**Heyford Park, Camp Road, Upper Heyford,  
Bicester, OX25 5HD**

**23/01959/NMA**

**Proposal:** Non-material amendment to 16/02446/F - amended elevation plans for 7 plots (plots 630-632, 634-635 & 646-647)

**SIDE ELEVATION**

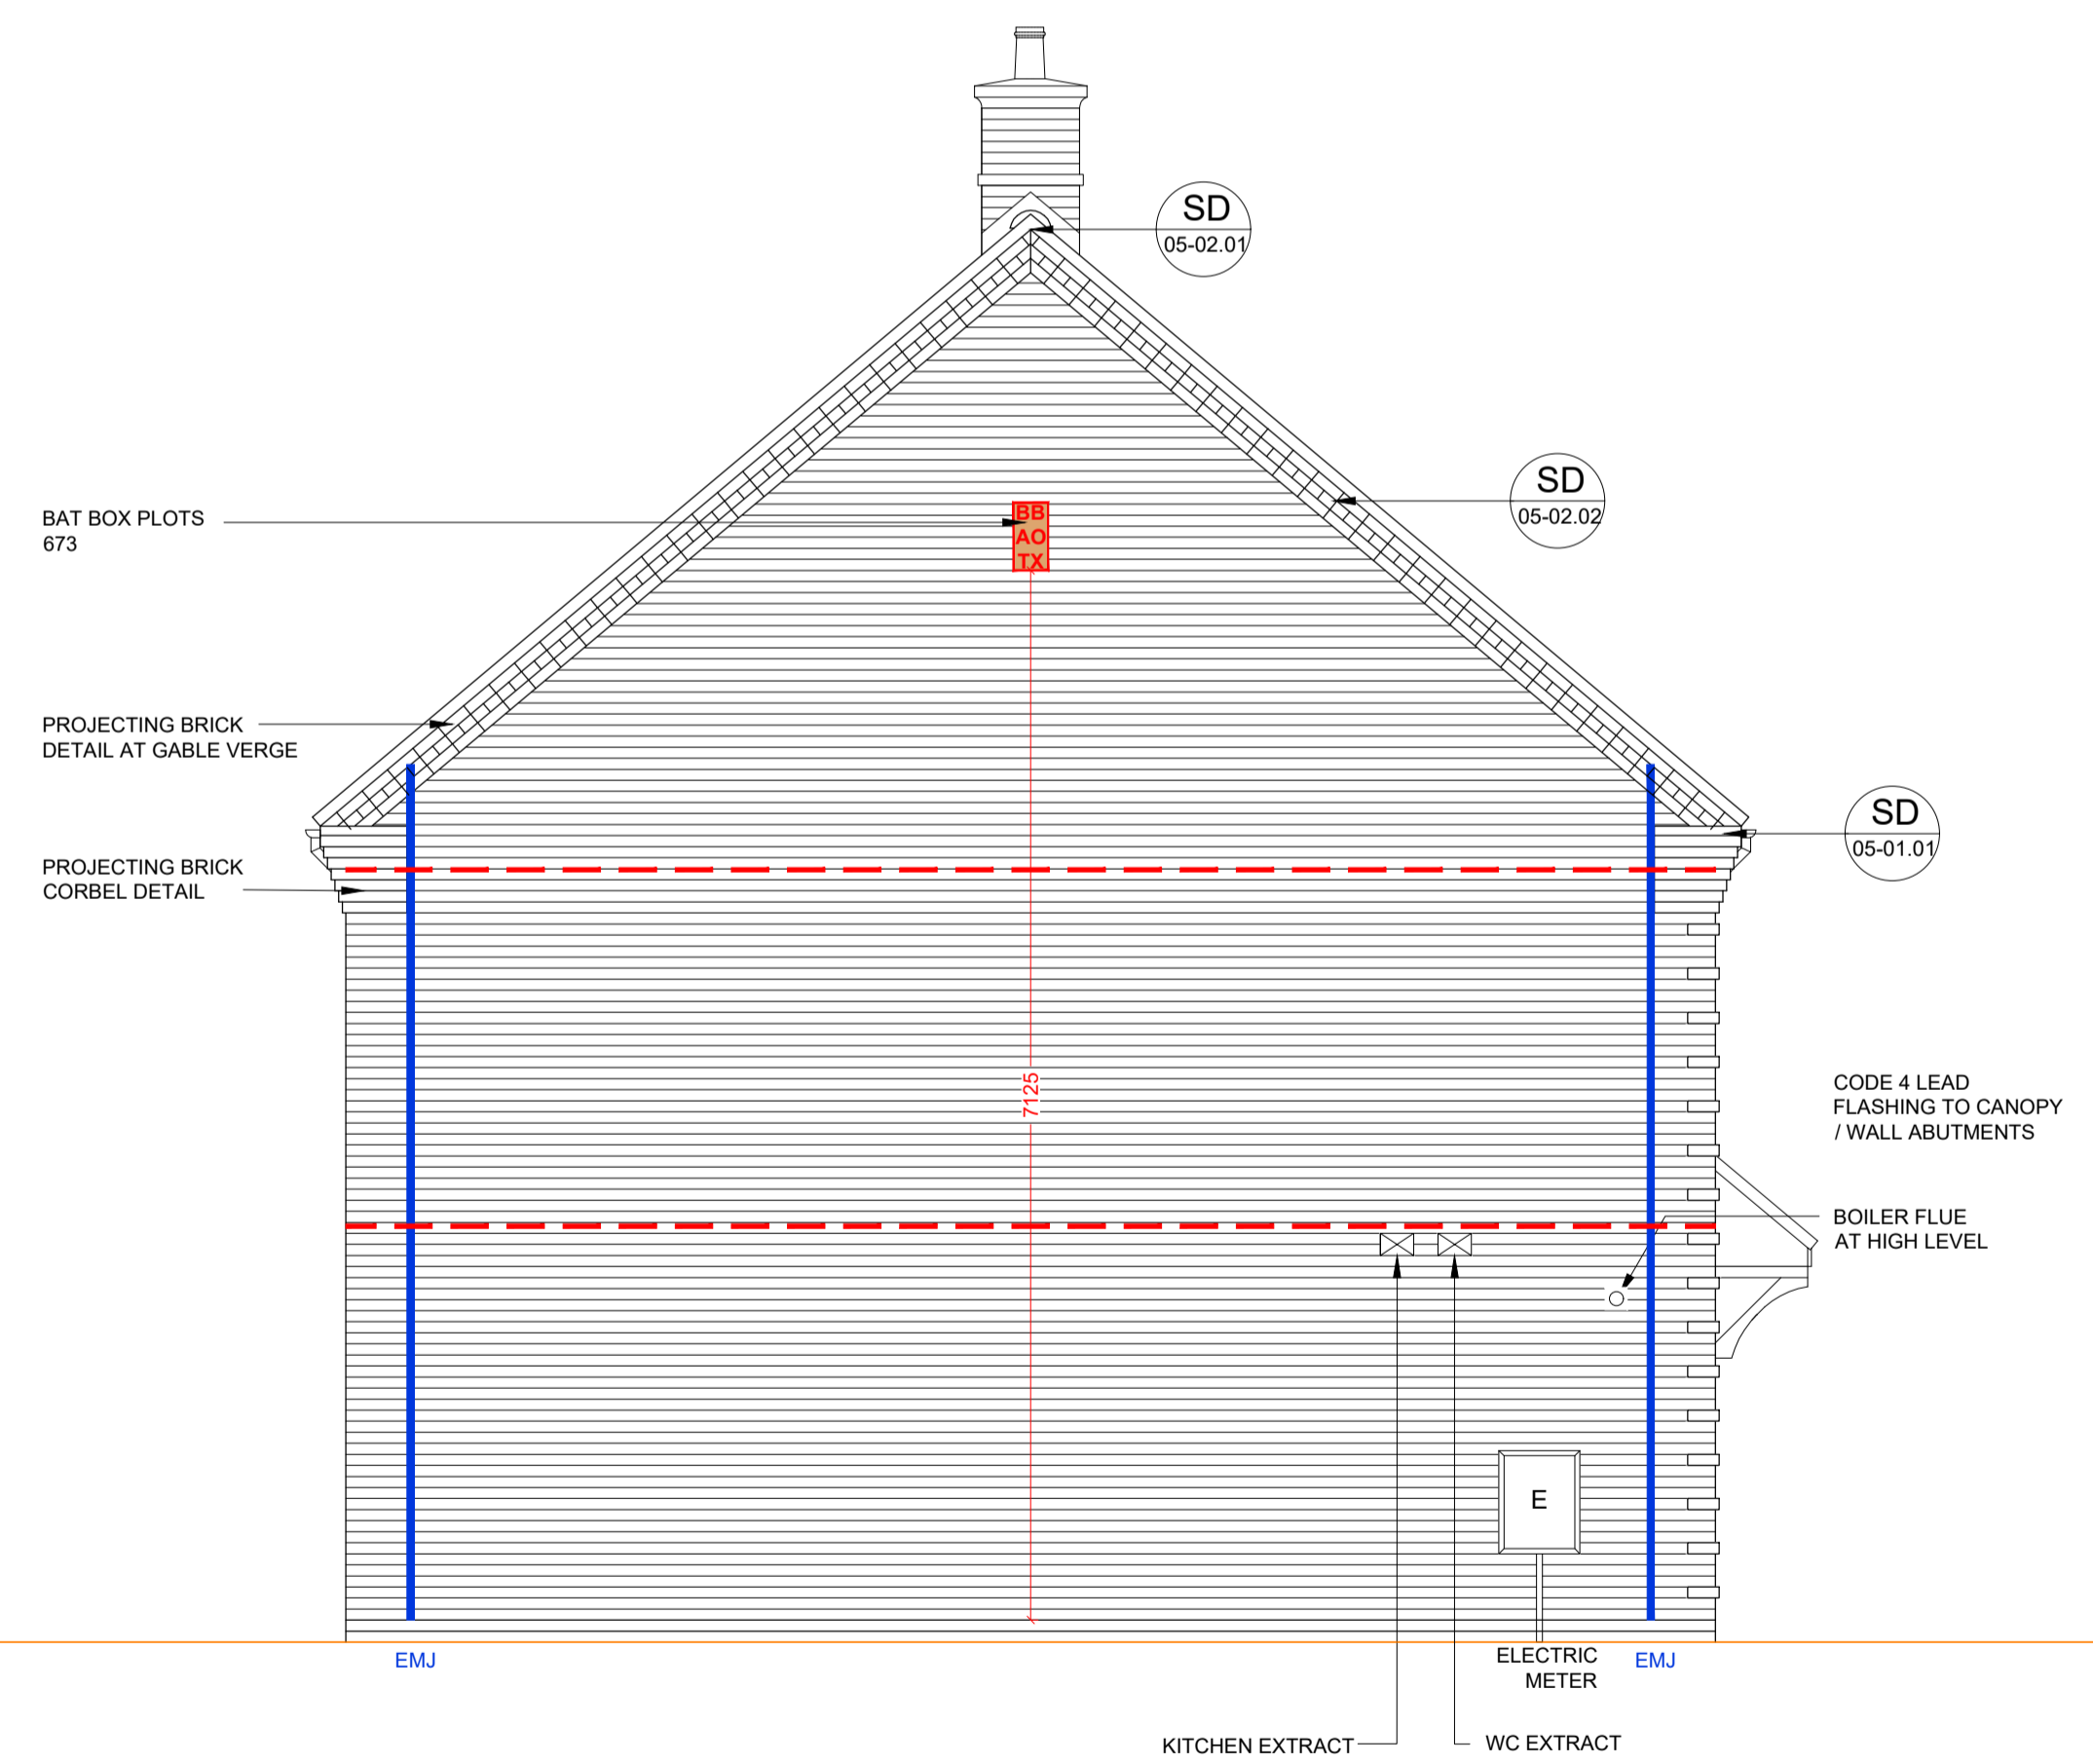
### House Type DL2v2 – Plot nos.634 and 635

- Bay window added to plot 634;
- Fanlight added above front door;
- Windows increased in height;

- Brick quoin detail added to front elevation corners;
- Stone detailing replaced with flat brick arches.
